Our Case Number: ACP-323977-25

Re: The proposed expansion of the existing landfill facility at the existing Knockharley Landfill in the townlands of Knockharley, Flemingstown and Tuiterrath Navan, Co. Meath

An Coimisiún Pleanála Case Reference: PA17.323977

The proposed expansion of the existing landfill facility at the existing Knockharley Landfill

Drawing Title
LANDSCAPE MITIGATION PLAN

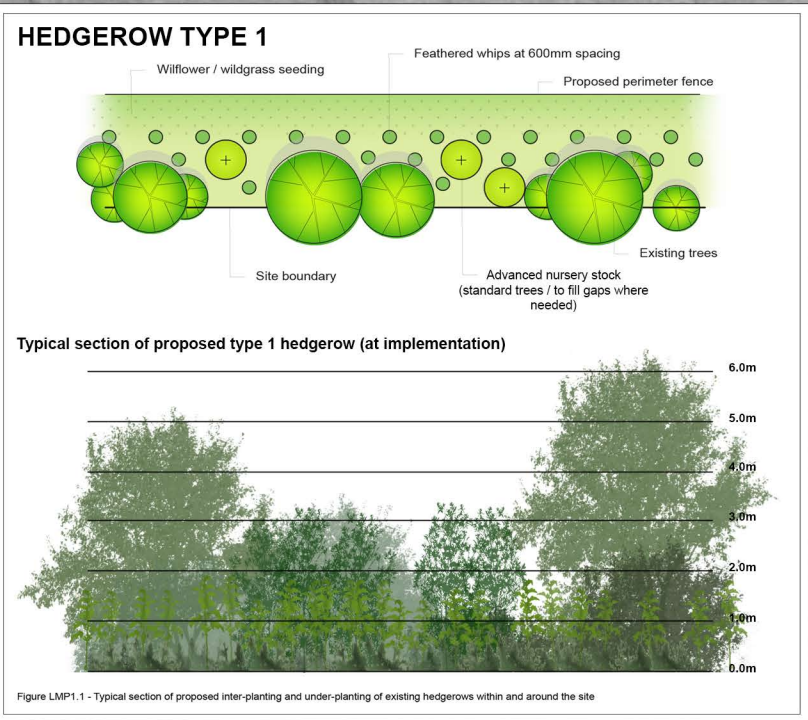
2.2. The Proposed Extension removes most of the planted area per the image below (see ringed red area) and in particular contains an area that is very much exposed (see arrow in yellow) given the proposed routing of electricity pylons along the actual boundary of the site means there is no further area in which tree screening can remain, nor in which a material earth berm that could provide some screening could be constructed or in which area of existing forest screening could remain. It should be noted that no image mock-up has been provided with the application which shows what the development will be like, including during construction phase, where all buffer to the west has been removed. It should be further noted that no assessment has been undertaken as to the viability of placing transmission wires underground for a section of the grid route, to allow for potential screening/planting to take place along the western boundary. Further, no alternate design has been

submitted whereby the Proposed Expansion area is reduced, to allow for alternate pylon layout, alongside meaningful berm and tree screening on the western boundary.

Image source – File on ACP portal Applicant documents>Application Documents>drawings>Macroworks> 20251105_05_LD_Project_West (Landscape Plan).pdf

2.4. We submit that the removal of existing mitigants, the significant visual impact of the routing of electricity pylons, and a lack of sufficient replacement mitigants on the western boundary the much reduced mitigant measures has not been fully assessed by the Applicant, and the Proposed Extension should be refused.

PROJECT				
PROPOSED LANDFILL DEVELOPMENT				
TITLE				
PROPOSED LEACHATE INFRASTRUCTURE				
PROJECT NO.	SCALE	REV.	of	DRAWING
IE0037029.9627	1/2500 @ A1	B		031

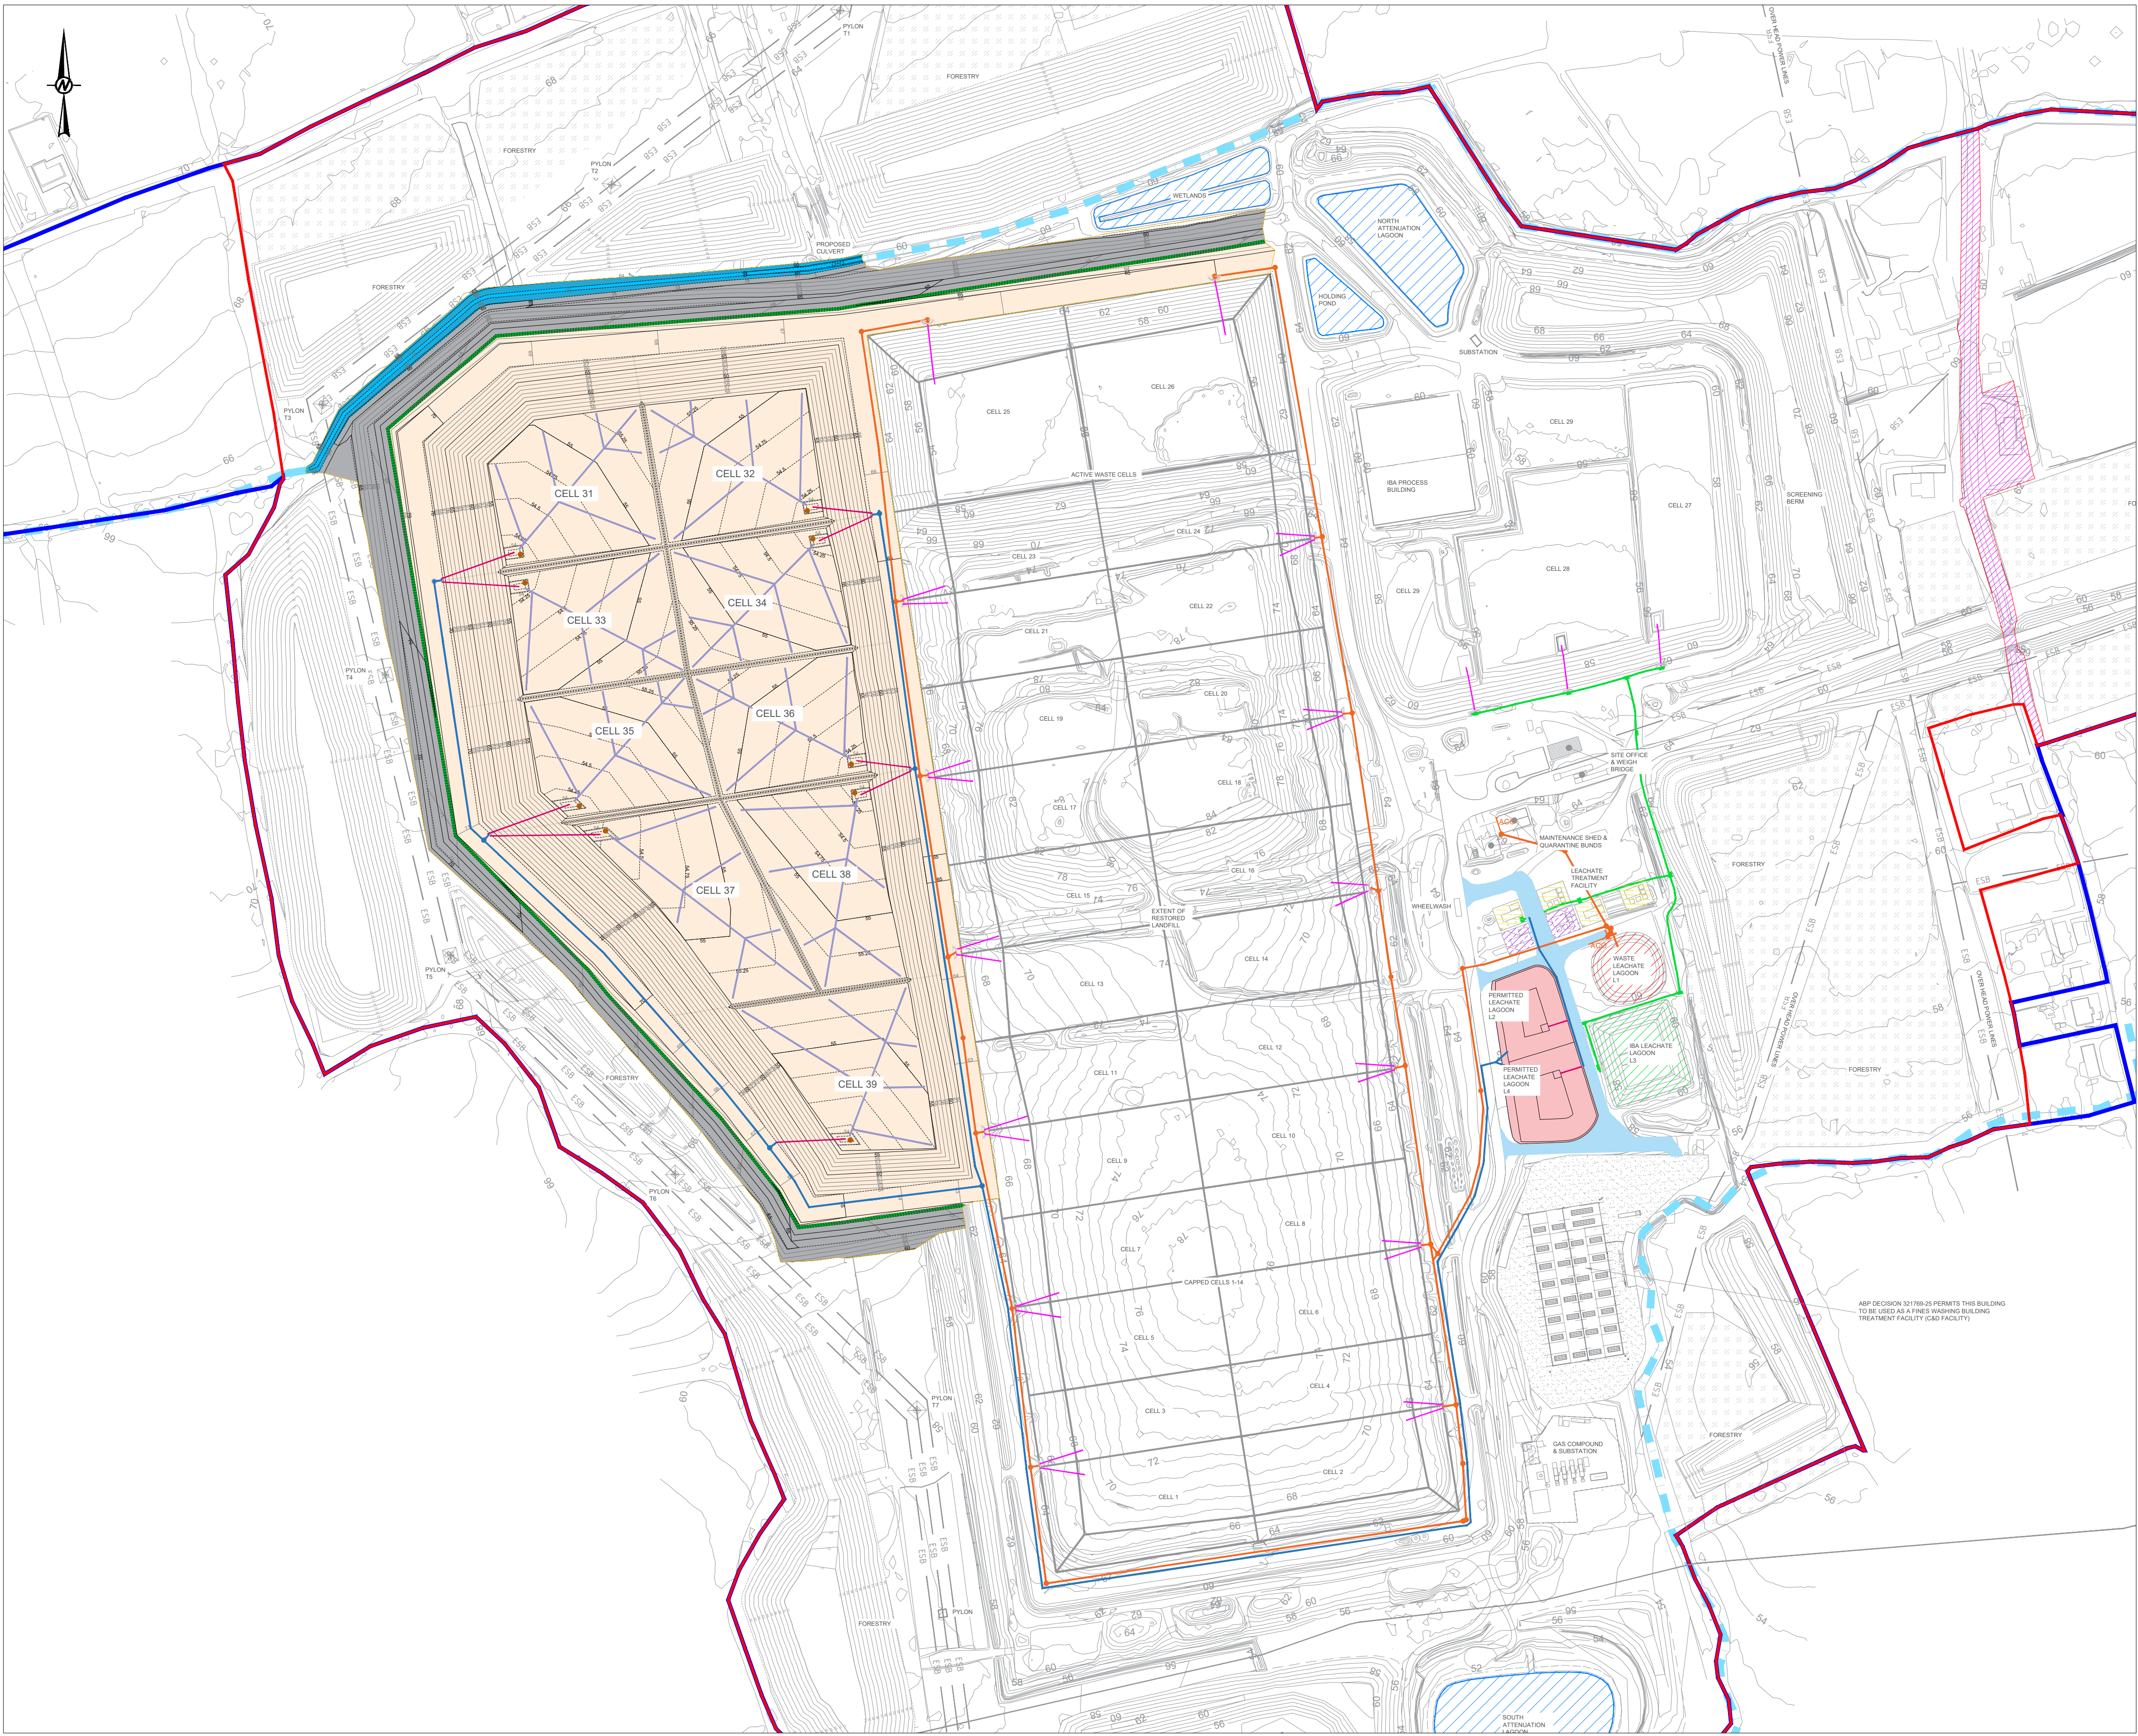
- 5.1.8. It is not clear what the capacity of the leachate lagoons on site are and whether such lagoons could overflow during a high rain event.
